WEST SUSSEX COUNTY COUNCIL CONSULTATION

TO:	Arun District Council FAO:Mr A Wood
FROM:	WSCC - Highways Authority
DATE:	2 June 2020
LOCATION:	Spindlewood Yapton Lane Arundel BN18 0AS
SUBJECT:	WA/30/20/PL Demolition of existing dwelling & erection of 8 No. dwellings with associated landscaping, parking & works. This application is a Departure from the Development Plan.
DATE OF SITE VISIT:	n/a
RECOMMENDATION:	No Objection
S106 CONTRIBUTION TOTAL:	n/a / £ See below for breakdown.

Drawing No.
DPA 02

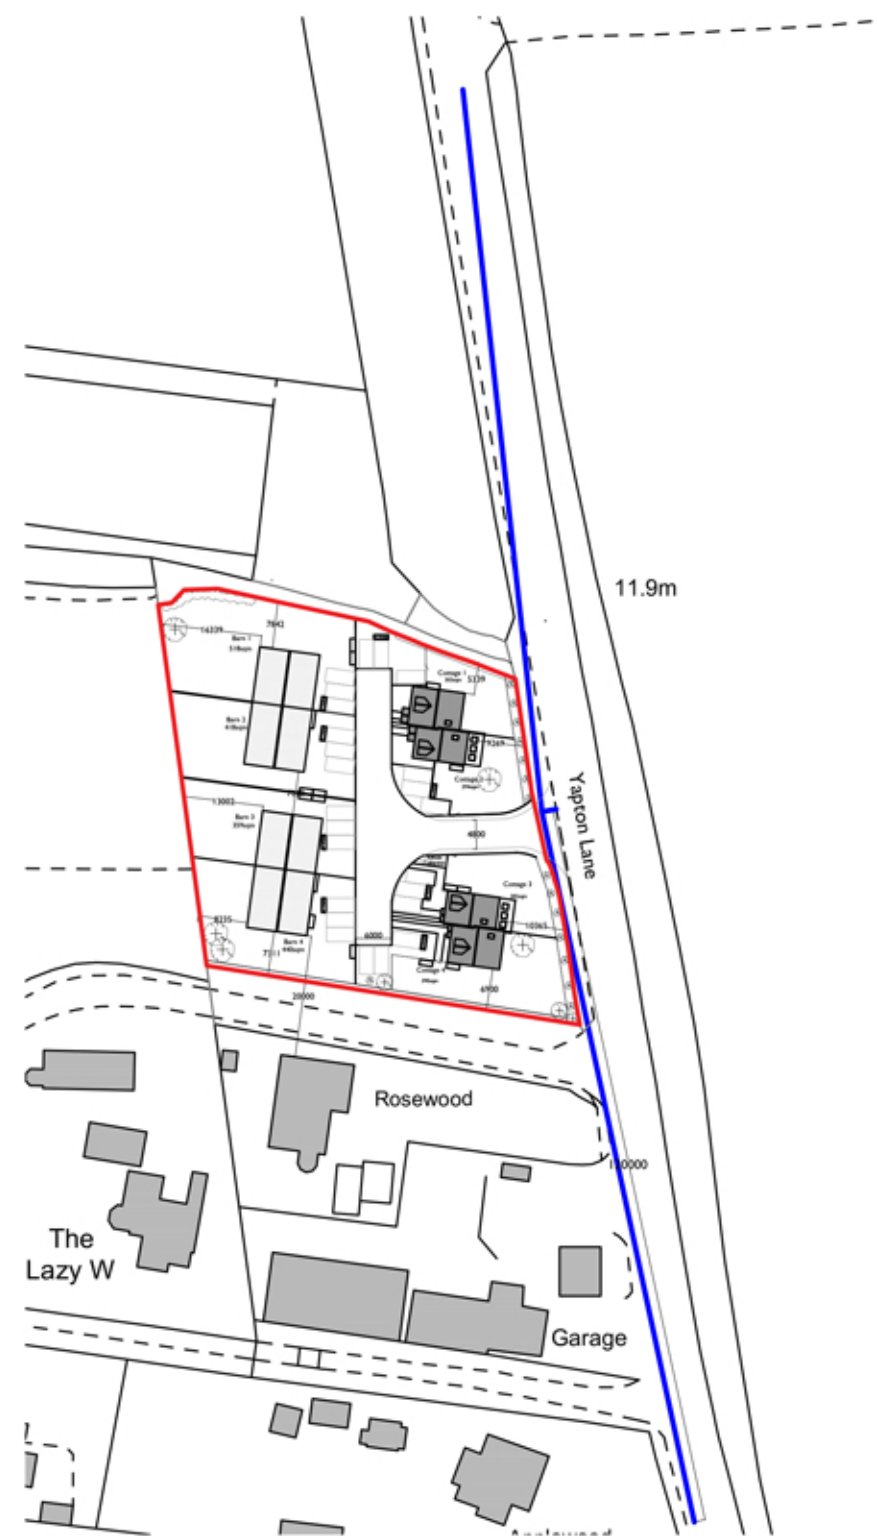
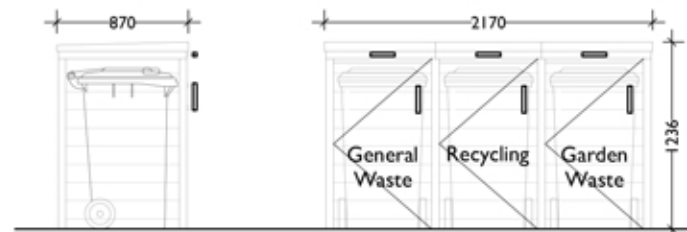
Plan DPA-02 provides evidence of the proposed visibility splays of 2.4m x 120m in both directions, which is in line with DMRB standards for a 40mph road. Visibility from this access provides 120m in both directions set back 2.4m from the access. WSCC are satisfied this access meets the required standards, and a s278 agreement will need to be progressed with the Implementation Team.

The proposed site plan indicates the layout will be shared use, which is acceptable where volumes of motor traffic is below 100 vehicles an hour, and in short lengths, or where they form cul-de-sacs. The site meets both criteria, and as Yapton Lane does not provide footways it would be in keeping with the natural layout of the adjoining road.

Parking provision has been calculated for 24 cars, 3 spaces are located outside each dwelling, all of which have 3 bedrooms. This parking layout has been assessed using the WSCC car parking calculator, using a parking allocation of 2 spaces per property. This creates a parking demand for 24 spaces, assuming the third space will be unallocated. Based on the calculator results WSCC are satisfied the development provides enough parking for the proposed development.

WSCC will require the access is built prior to any construction works as the current access would not be wide enough. Should the applicant wish to create a temporary access this will need to be approved by a temporary s278 agreement.
